An
Coimisiún
Pleanála

Inspector's Report ACP-324064-26

Whether the alteration of the existing stone boundary wall for the purpose of creating a new opening is or is not development and is or is not exempted development

Bishop's House, Old Dublin Road, Co. Carlow

Figure 2.1: Existing and proposed elevations of stone wall. (Source: Eugene Keyes c/o Bishop's House, Carlow).

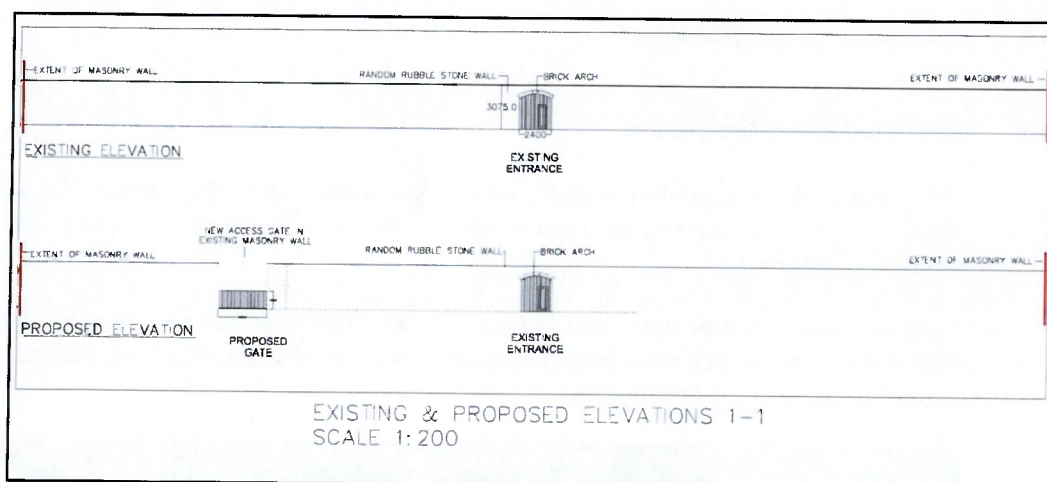
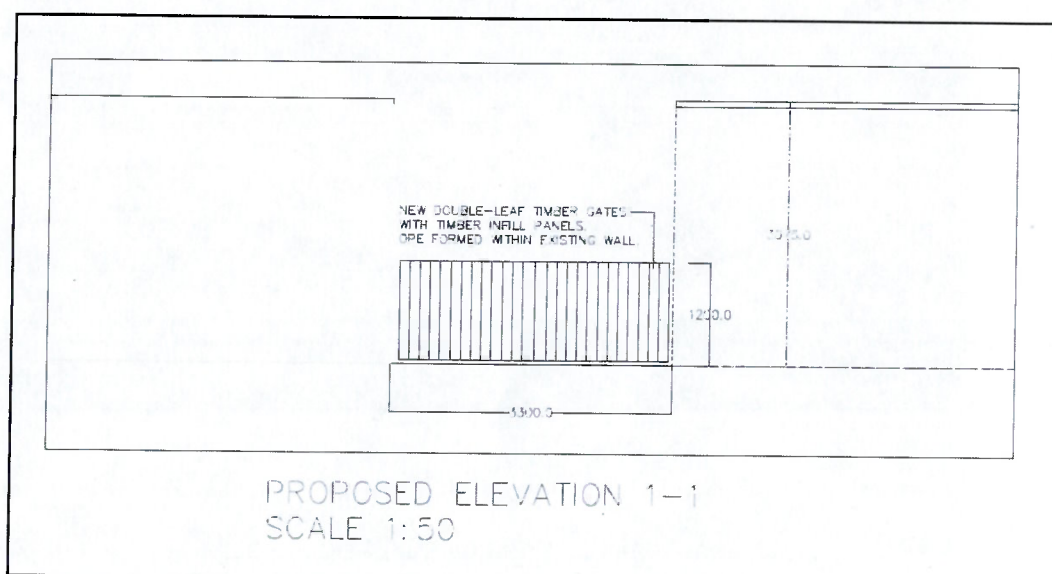
- 2.2. The drawings submitted with the declaration indicate part of the existing boundary wall facing Old Dublin Road would be demolished and a double leaf timber gate installed in the wall measuring 1.2m in height and 3.3m in width.
- 2.3. This entrance would be set back from the frontage of the Old Dublin Road by c.18.2m and would be set in from the side boundary of No.10 Old Dublin Road by 8.5m. It would access the Bishop's Palace area of the site and would be to the south of the existing gated arched entrance along this wall.
- 2.4. I therefore consider the question should be rephased as to whether the alteration of the existing stone boundary wall on the grounds of Bishop's House, Old Dublin Road, Carlow, and the installation of a 1.2m high timber gate for the purpose of creating a new opening constitutes development.

- 8.3.3. I consider the works proposed to the boundary wall would not be exempt by virtue of Section 4 (1) (h) as I consider the works proposed would materially affect the external appearance of the boundary wall so as to render the appearance inconsistent with the remaining wall along the Old Dublin Road frontage.

8.3.6. Notwithstanding that I do not consider the property to which the site forms a part is a dwelling, to alter or form a structure, under Class 5 if considered a residential property, the height of such a structure is limited to 1.2m to the front of the house or 2m elsewhere under this class. The existing boundary wall is 3m in height and would support the proposed gate and the new opening and therefore the new opening and associated gate would not therefore come within the scope of Class 5 of Schedule 2, Part 1 of the Regulations, being greater than 1.2m and 2m in height.

8.4.1. Having regard to the foregoing, the alteration of the existing 3m high stone boundary to create an opening of 3.3m width and the erection of a timber gate with a height of 1.2m on the grounds of Bishop's House, Old Dublin Road, in Carlow, is development and is not exempt development.
